Application for the approval of Reserved Matters pursuant to condition 1 (Reserved Matters details), condition 6 (Design Code Masterplan) & condition 7 (landscaping & layout details) following the grant of P/134/16/OUT for the erection of 250 No. dwellings, (including affordable homes), replacement scout hut, land for an Ambulance Community Response Post Facility, demolition of No. 80 Rose Green Road & provision of Public Open Spaces including associated children's play areas, landscaping, drainage & earthworks (resubmission following P/24/20/RES). This site also lies within the parish of Aldwick.

Pagham Parish Council wishes to OBJECT to this application on the following grounds:

LAP-1 PLAY EQUIPMENT

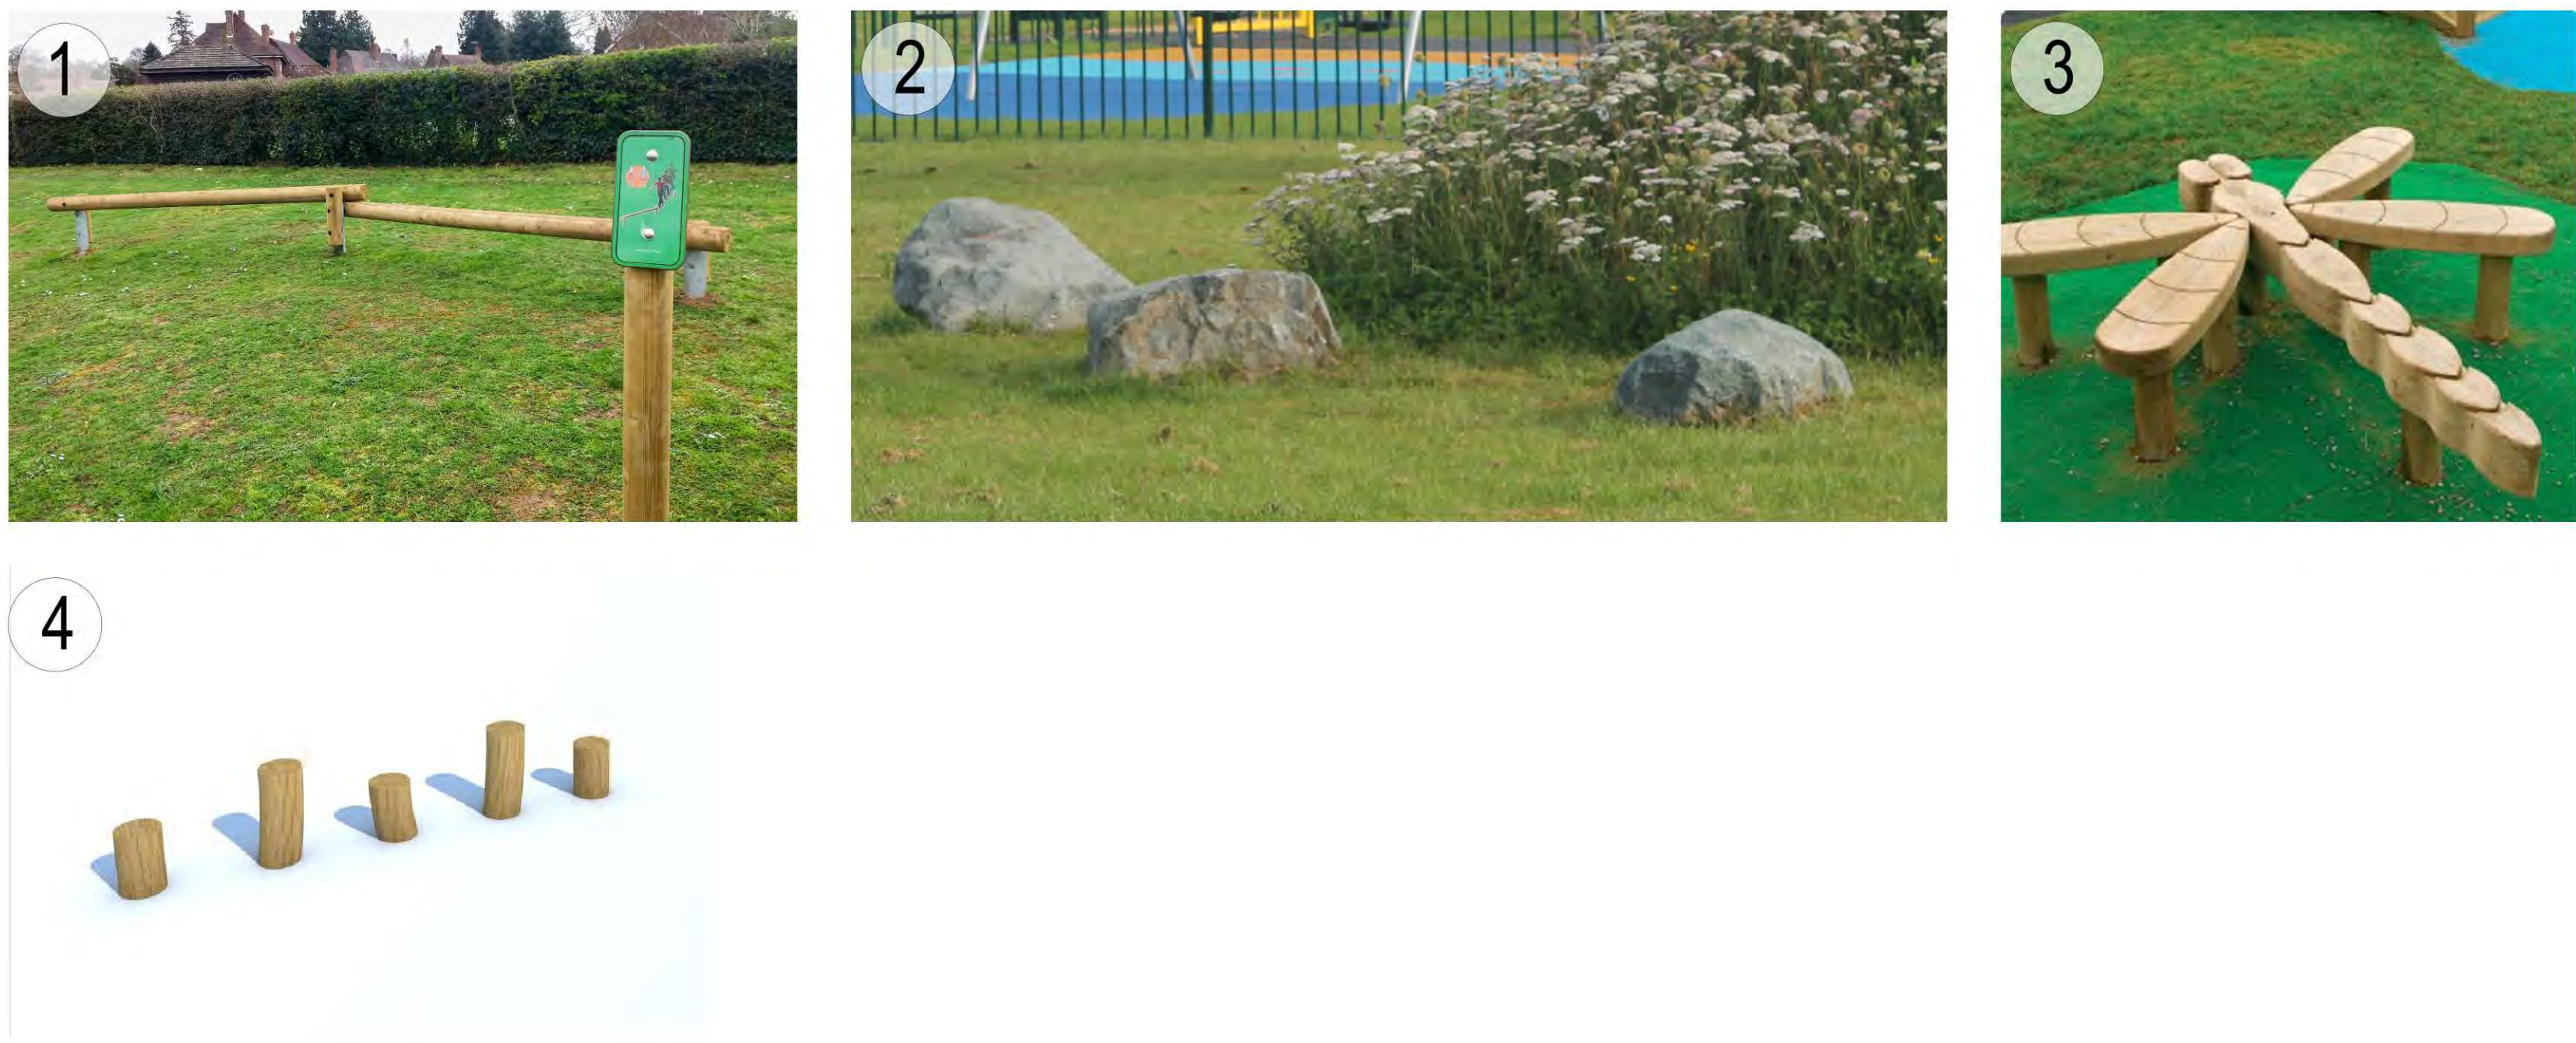
The Council has concerns over the quality of the play space equipment on offer. In particular, the play value and safety of the boulders was questioned. Members did not feel the equipment on offer was particularly imaginative. In LAP 1, a tree trunk to be sourced from the site was to be included in the play area. This is not suitable – Robinia is a far better material as it does not splinter or degrade.
